Town & Country Planning Act 1990 (as amended)
Town and Country Planning (Development Management Procedure) (England) Order 2015
Application for approval of details reserved by condition imposed under planning permission
BR/292/16/PL (Appeal ref. APP/C3810/W/17/3169745) relating to condition No. 2 2) Details of the
head, sill, mullions, jambs & glazing of the replacement windows on the North East elevation
1 Regis House Richmond Road, Bognor Regis,

Condition Number 2

Arun District Council have decided to **REFUSE details reserved by condition for the following reasons:**

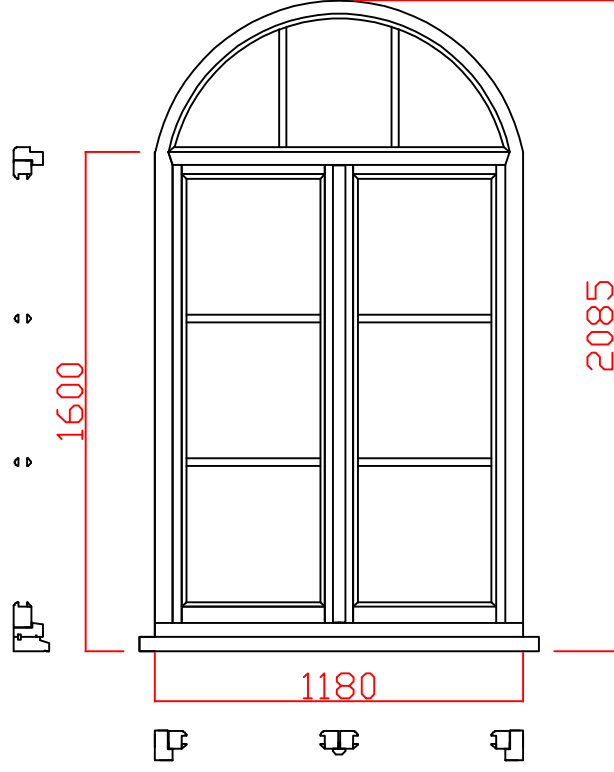
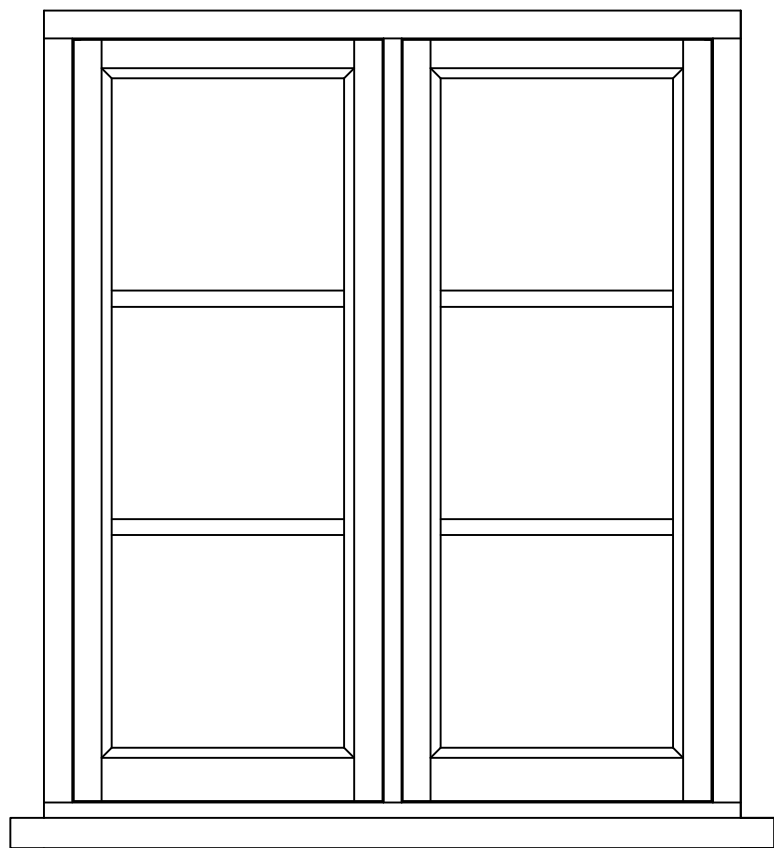
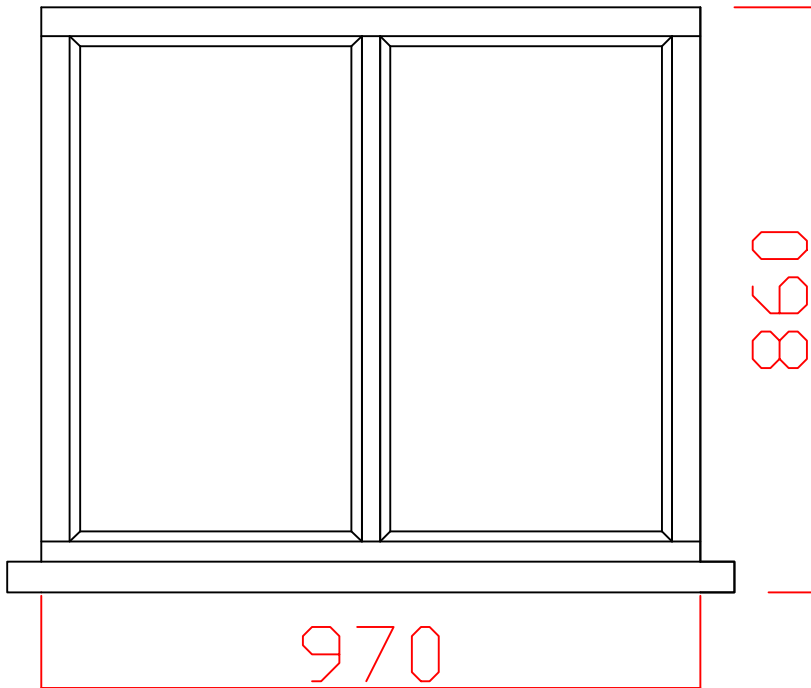
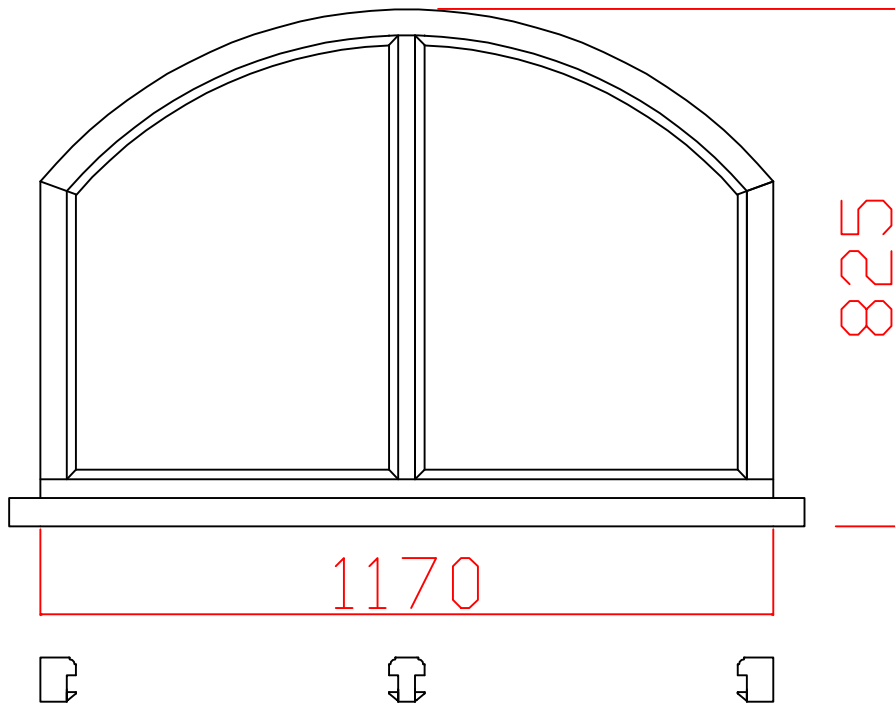
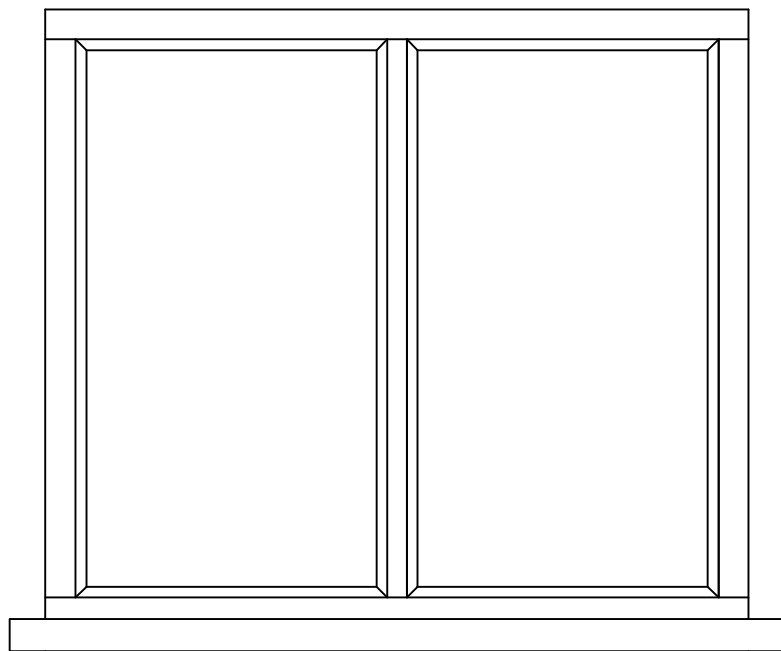
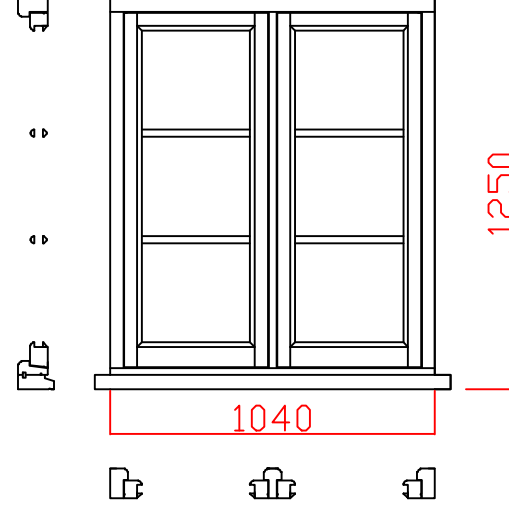
The submitted plans of joinery details are insufficient to make a decision. They are unscaled, and do not describe elements as set out in the Appeal Decision. It is also noted that no block plan has been submitted to locate the windows being replaced.

Before any development begins, details of the head, sill, mullions, jambs and glazing of the replacement windows on the north east elevation at a scale of not less than 1:20 shall be submitted to the local planning authority and approved in writing. The development shall be carried out in accordance with the approved drawings.
